Conservatory to rear & side walls. Porch to front entrance door & realignment of existing boundary wall

44 Merryfield Crescent Angmering

Thank you for your internet comments made on 23rd May 2012 and recorded as follows:

AJ SALTER & SON
 Architectural Technicians
 and Surveyors
 50 WINDSOR ROAD, WORTHING,
 WEST SUSSEX, BN11 2LY
 Tel/Fax: (01903) 209496
 E-mail: ajsalterandson@hotmail.com

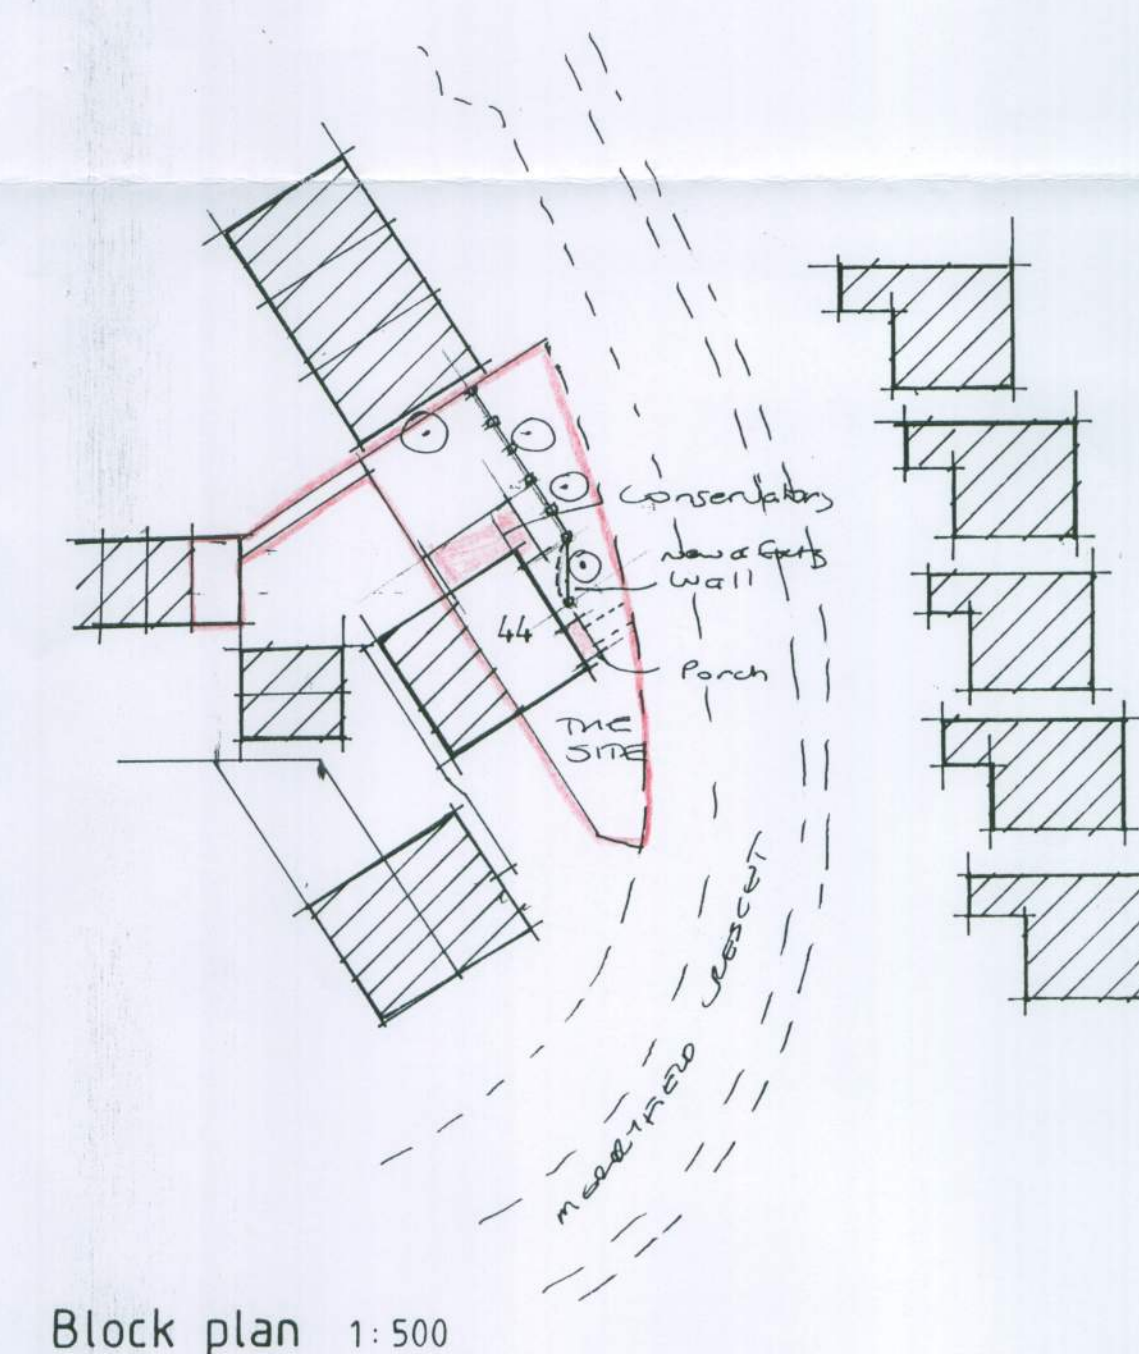
DECISION: No objection to the Conservatory, but objection to the boundary wall being moved as there is no evidence provided that this will not adversely affect the nearby tree.
